EXHIBIT “B”

RE: Appeal of Land Use Approval for CAO23-011
October 23, 2023

TOPOGRAPHIC & BOUNDARY SURVEY

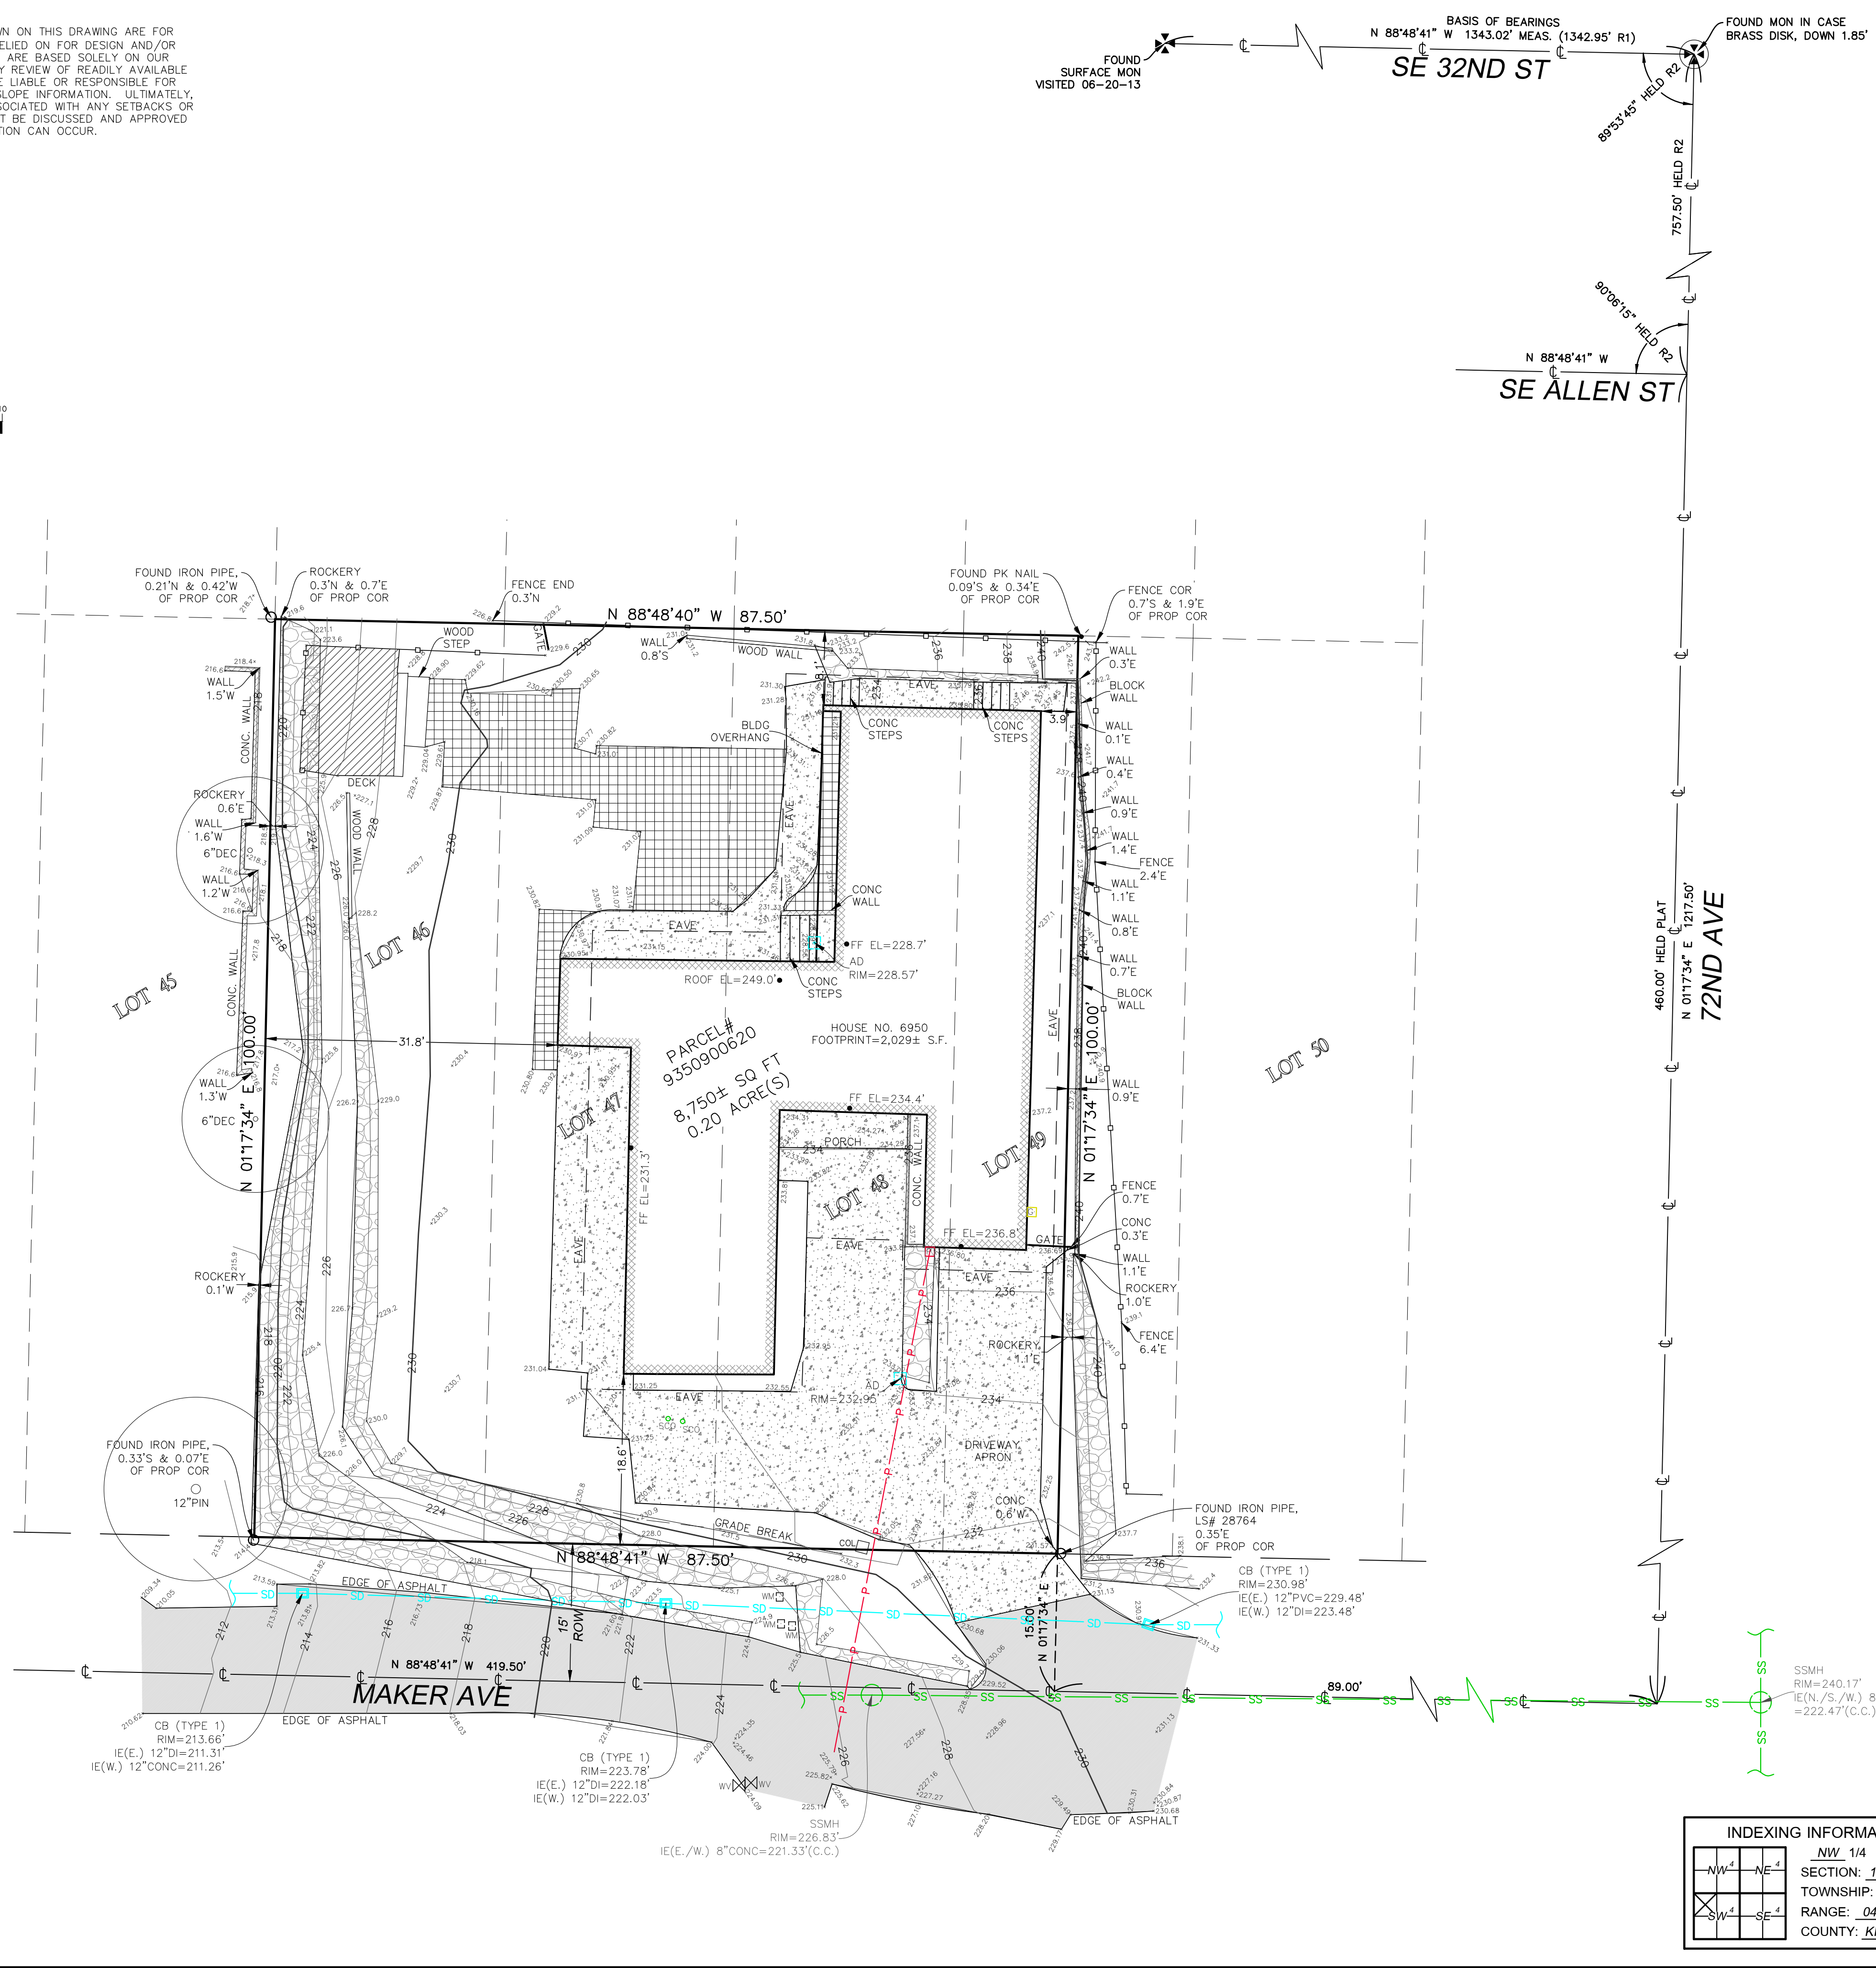
The 2021 survey of the Development Site shows the distance from the walkway on the western side of the existing house to the top and bottom of the retaining wall west of the house.

- The elevation of the Maker Street midline (shown in Blue in Figure 4) differs from 1963 to 2021 by only a few inches (despite the street being paved several times between the two surveys).
- At the south boundary of 6950 (in Green in Figure 4), the retaining wall that was added is clearly visible - there are up to 4 feet of difference between 1963 and 2021.
- The cross section 10' north of the boundary (in Red in Figure 4) shows that the retaining wall increased the elevation of the yard by 7.5 feet when comparing 2021 and 1963 elevations.

SECTION SH2 2
SCALE: 1/4" = 1'-0"

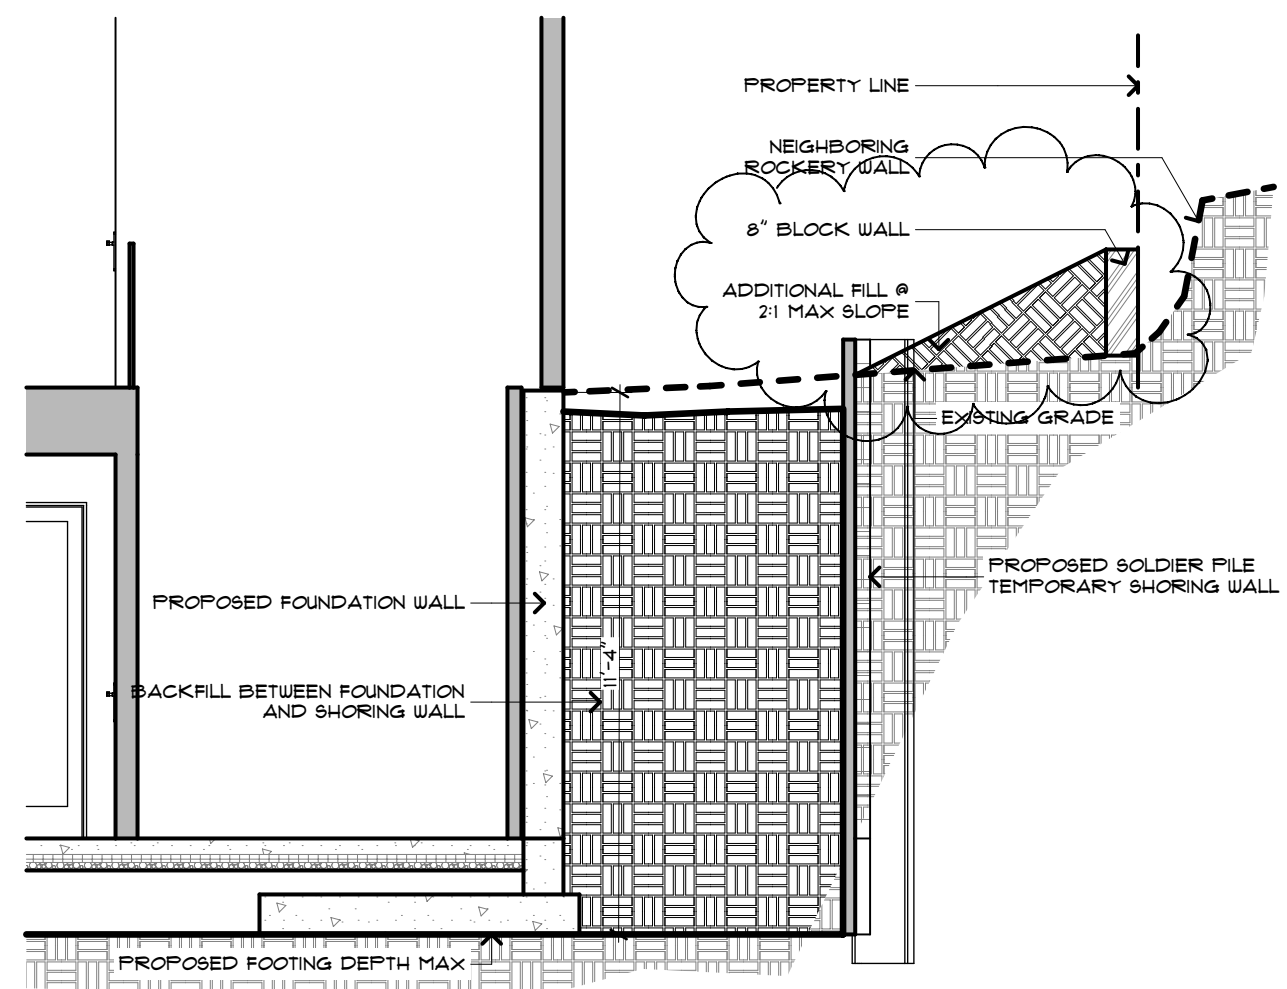
- 19.02.050(E)(1)(a)(i) - The proposed combined rockery + retaining wall for the fill slope in the western Required Side Yard and Required Rear Yard exceed the maximum allowed height of 72 inches above the lower of Existing Grade or Finished Grade. The proposed retaining wall in these yards is ~120" (Piles 23 through 37 in the table from CAO23-011 SUB2, sheet SH2 below).
- 19.020.050(E)(1)(a)(ii) - The proposed combined rockery + retaining wall for the fill slope in the Required Front Yard exceeds the maximum allowed height of 42 inches above the lower of Existing Grade or Finished Grade. The proposed retaining wall in these yards is ~120" (Piles 13 through 22 in the table from CAO23-011 SUB2, sheet SH2 below).

1. The heights of retaining walls containing fill in Required Yards must be reduced to 42" in the Required Front Yard, and 72" in the Required Side and Rear Yards. Note that MICC restricts the **combined** height of retaining walls + rockeries in each required yard. Therefore the remaining portions of the existing rockery and the new retaining/shoring walls must have their heights combined for comparison with MICC 19.02.050(E)(1)(a)'s requirements.
2. Fill that raised the Finished Grade to more than 72" above the Existing Grade must be removed.
